Our Ref: LM/ARU/20/25A

Date 2nd September 2020

RE: Land to the south of Ford Lane and East of North End Road Yapton BN18 0DS

Thank you for your correspondence of the 26th August 2020, advising me of a planning application for Approval of reserved matters following outline consent Y/80/16/OUT for 4.5ha of residential development comprising of 3.4ha of land for the erection of 100 No. dwellings (up to 30 (30%) affordable housing) together with 1.1ha of land set aside for public open space, strategic landscaping, 2.2ha of public open space, green corridors with vehicular access from Ford Lane & pedestrian/cycle access only from North End Road (resubmission following Y/19/20/RES). This application may affect the setting of listed buildings, affects the character & appearance of the Church Lane, Yapton Conservation Area & affects a Public Right of Way. This site falls within Strategic Site SP2 (Zero Rated) at the above location, for which you seek advice from a crime prevention viewpoint.

Title:
APARTMENT A
FLOOR PLAN AND ELEVATIONS

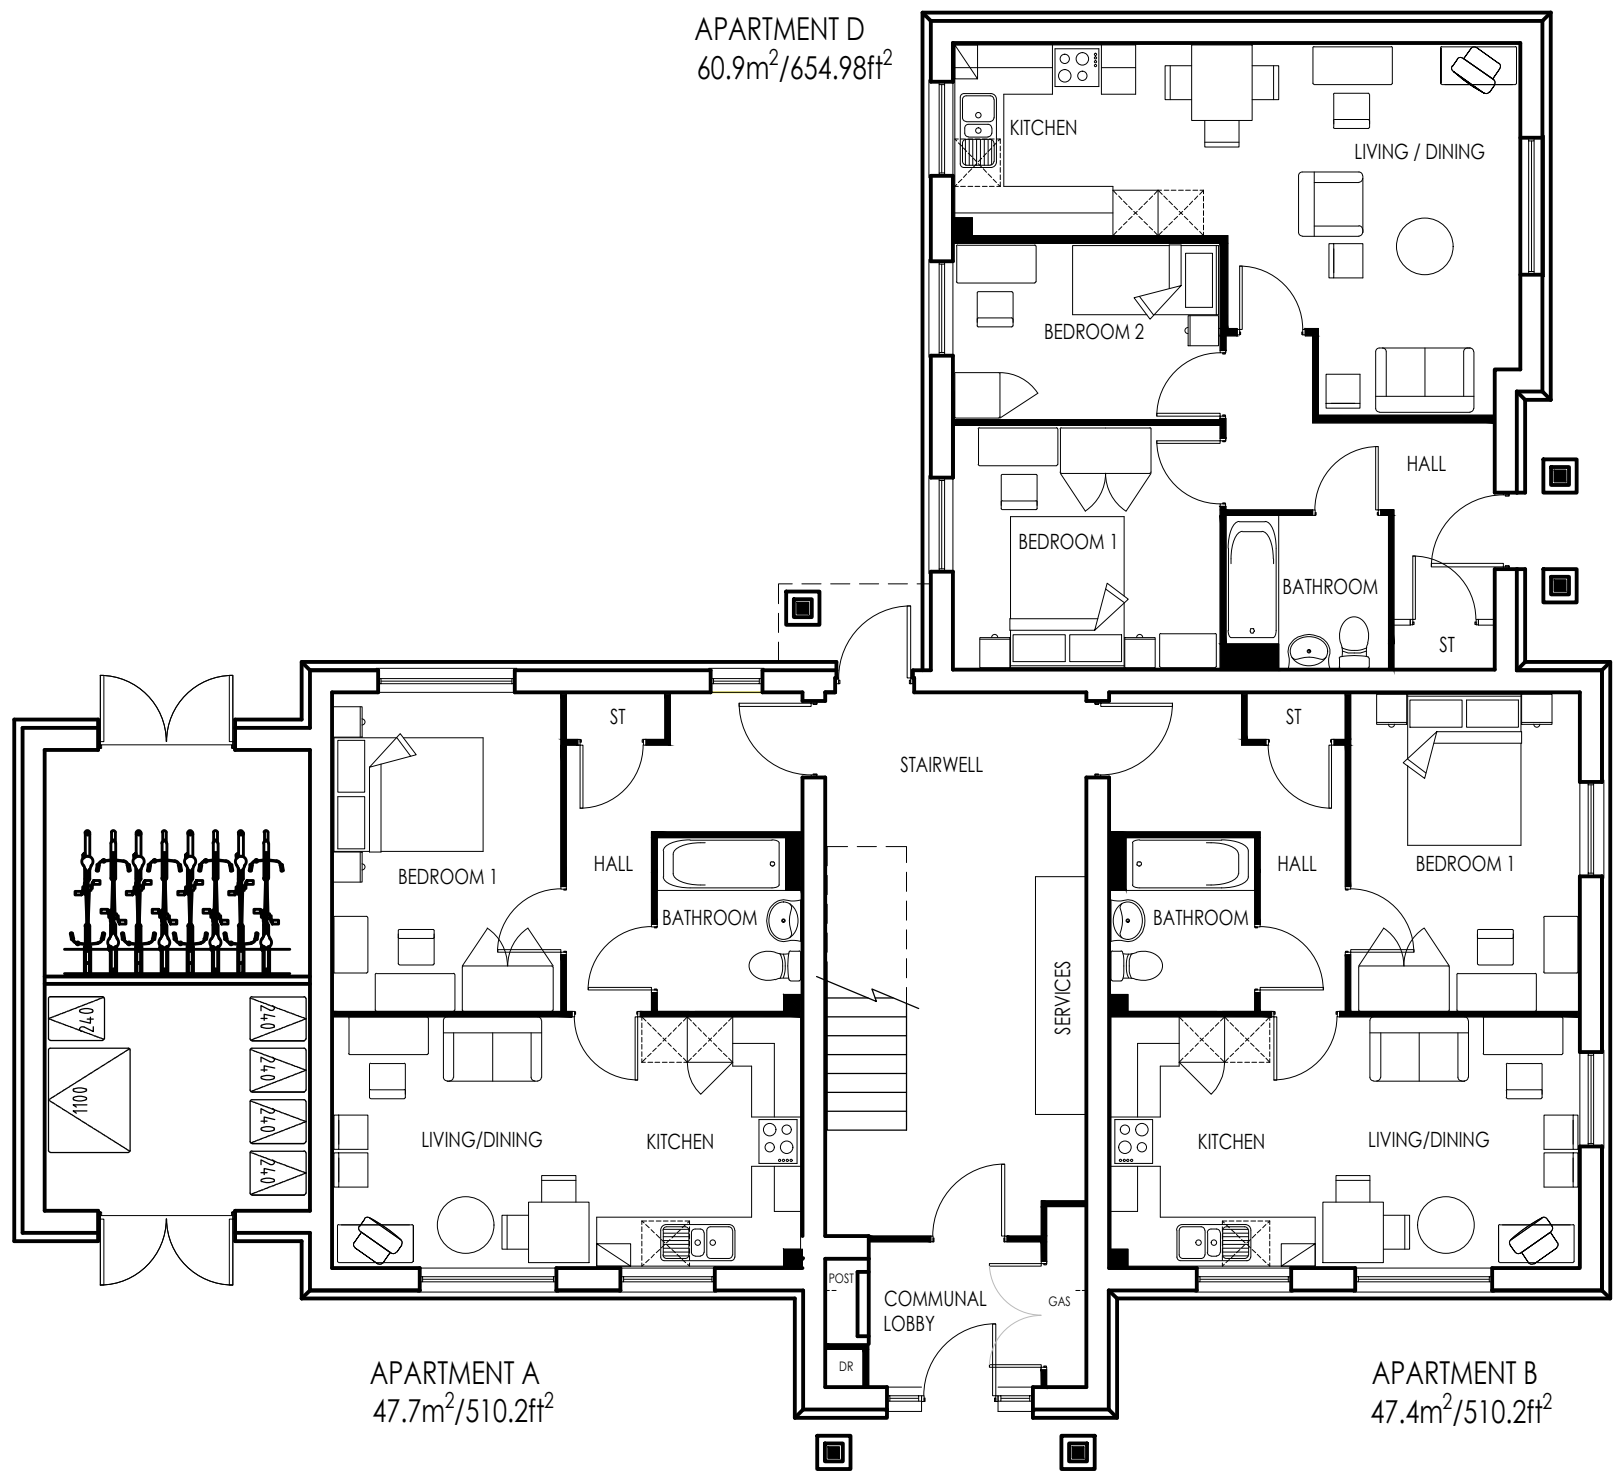
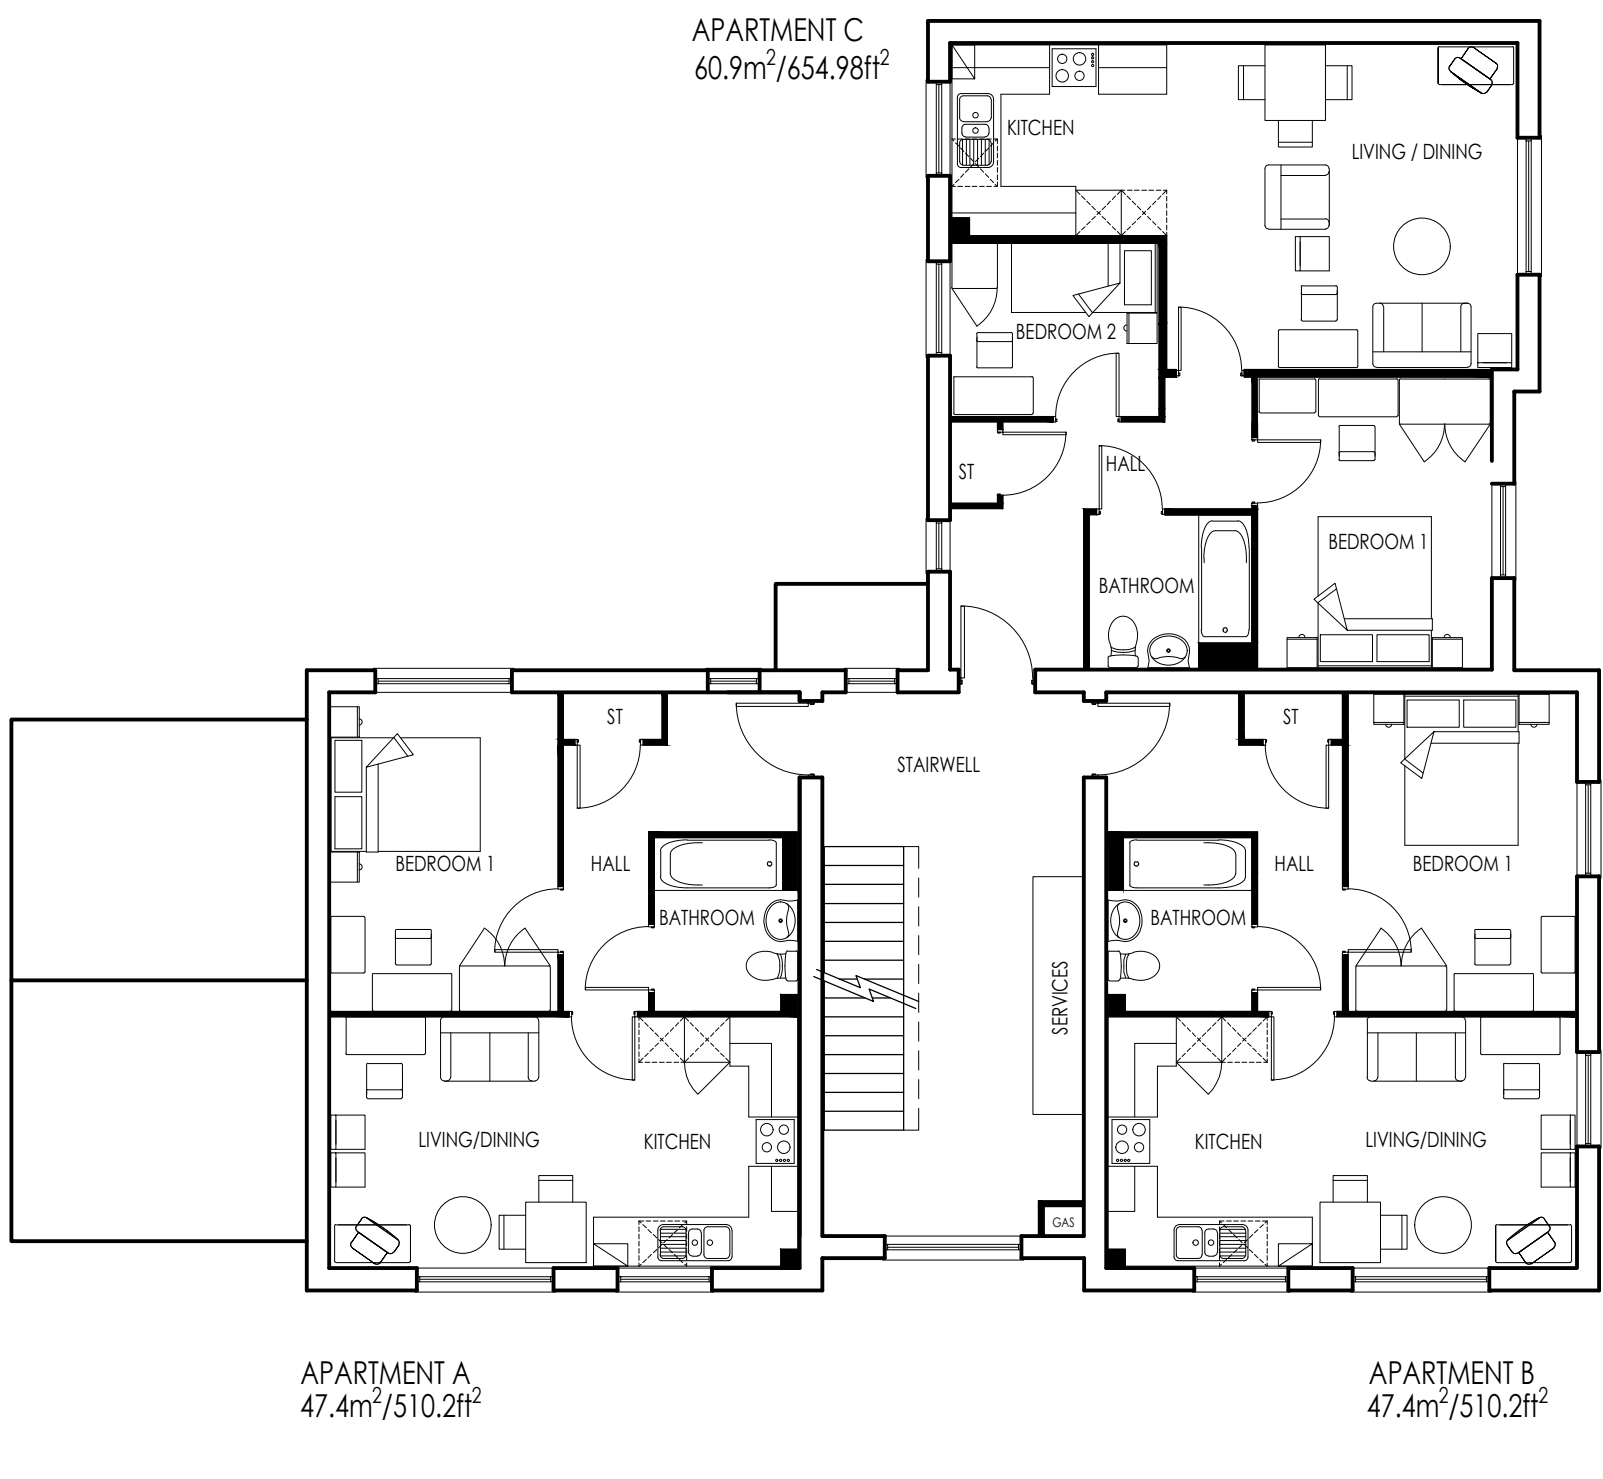
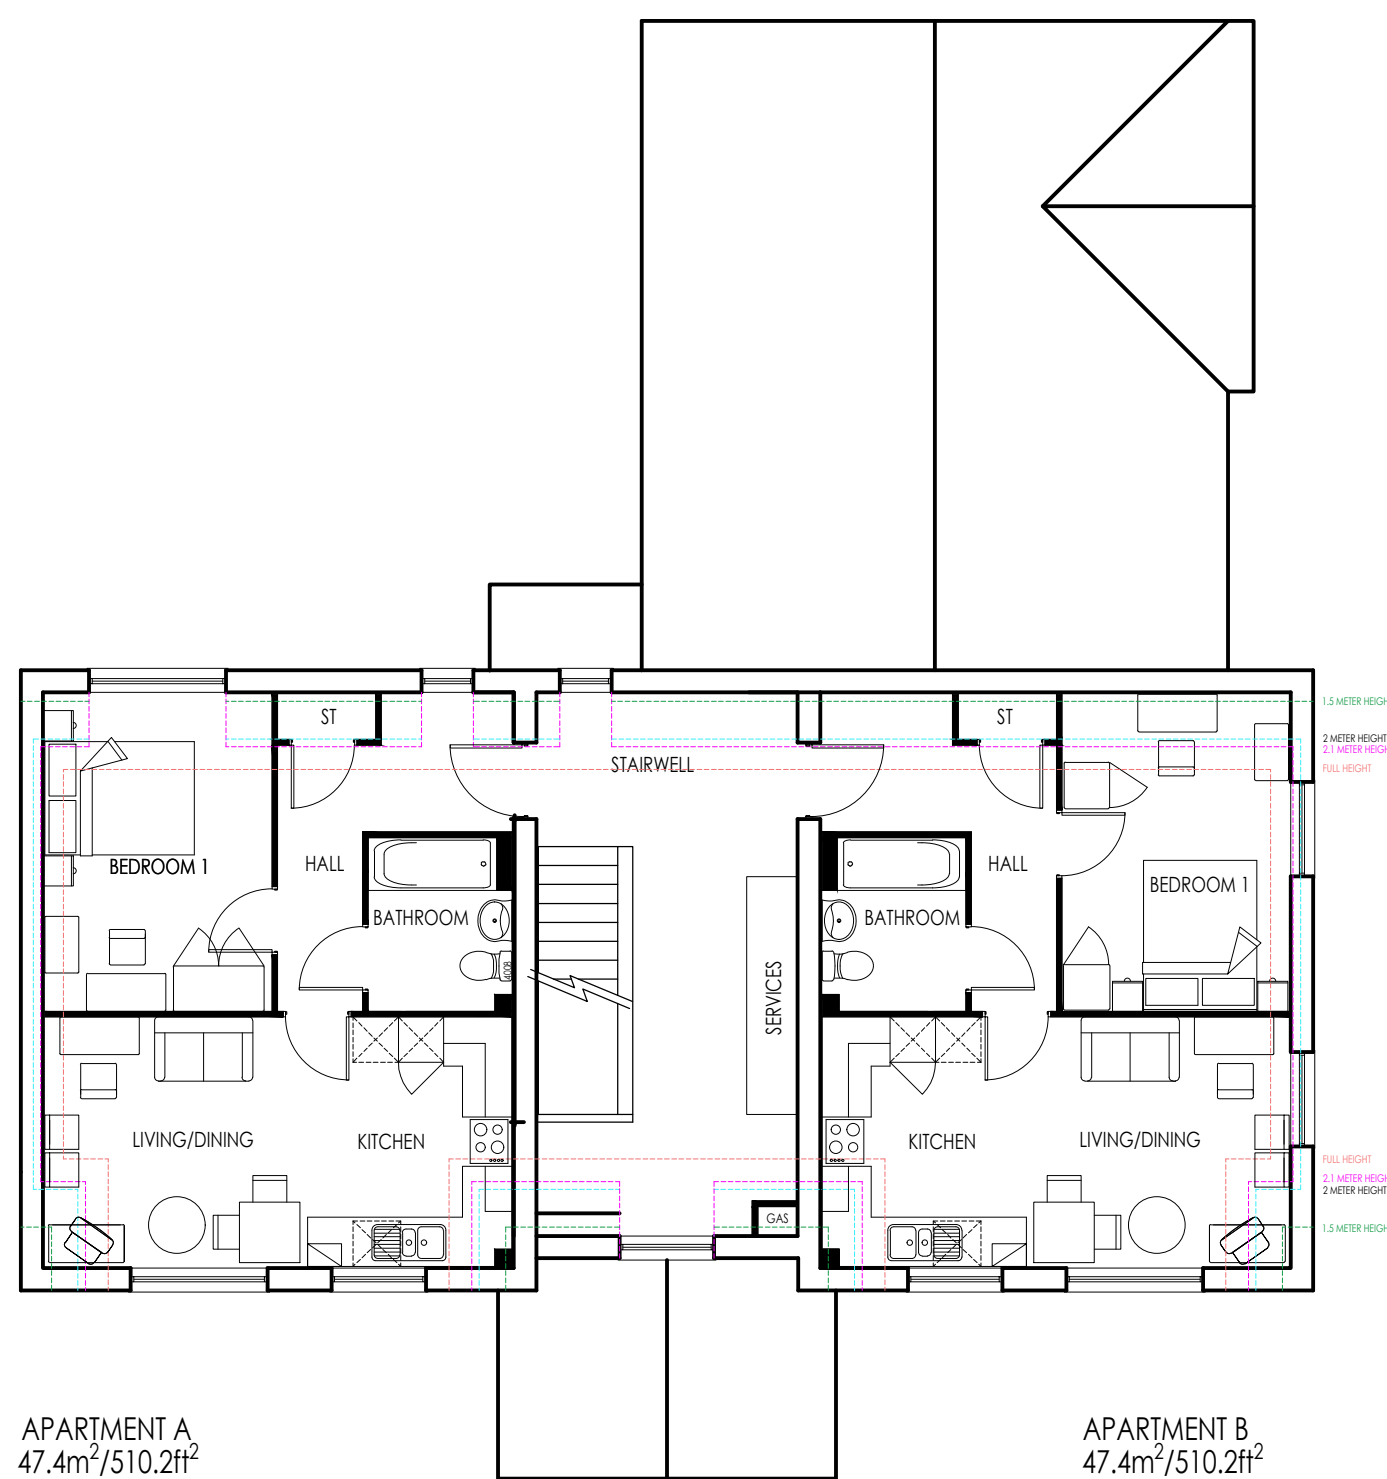
With regards to the apartments from a crime prevention perspective it will be imperative that access control is implemented into the design and layout to ensure control of entry is for authorised persons only. SBD recommends that all communal door-sets serving 5 or more dwellings or bedrooms should have visitor door entry system or access control system to enable management oversight of the security of the building i.e. to control access to the building via the management of a recognised electronic key system. It should also incorporate a remote release of the primary entrance door set and have audio visual communication (preferably colour) between the occupant and the visitor. I refer the applicant to SBD Homes Version 2 2019 Chapter 27 27:1 through to 27:28. Tradesperson or timed release mechanisms are not permitted as they have been proven to be the cause of antisocial behaviour and unlawful access to communal developments.

Additionally, I recommend the postal arrangements for the apartments is through the wall or externally mounted secure post boxes. I strongly urge the applicant not to consider letter apertures within the apartment's front doors. The absence of the letter aperture removes the opportunity for lock manipulation, fishing and arson attack and has the potential to reduce unnecessary access to the block.
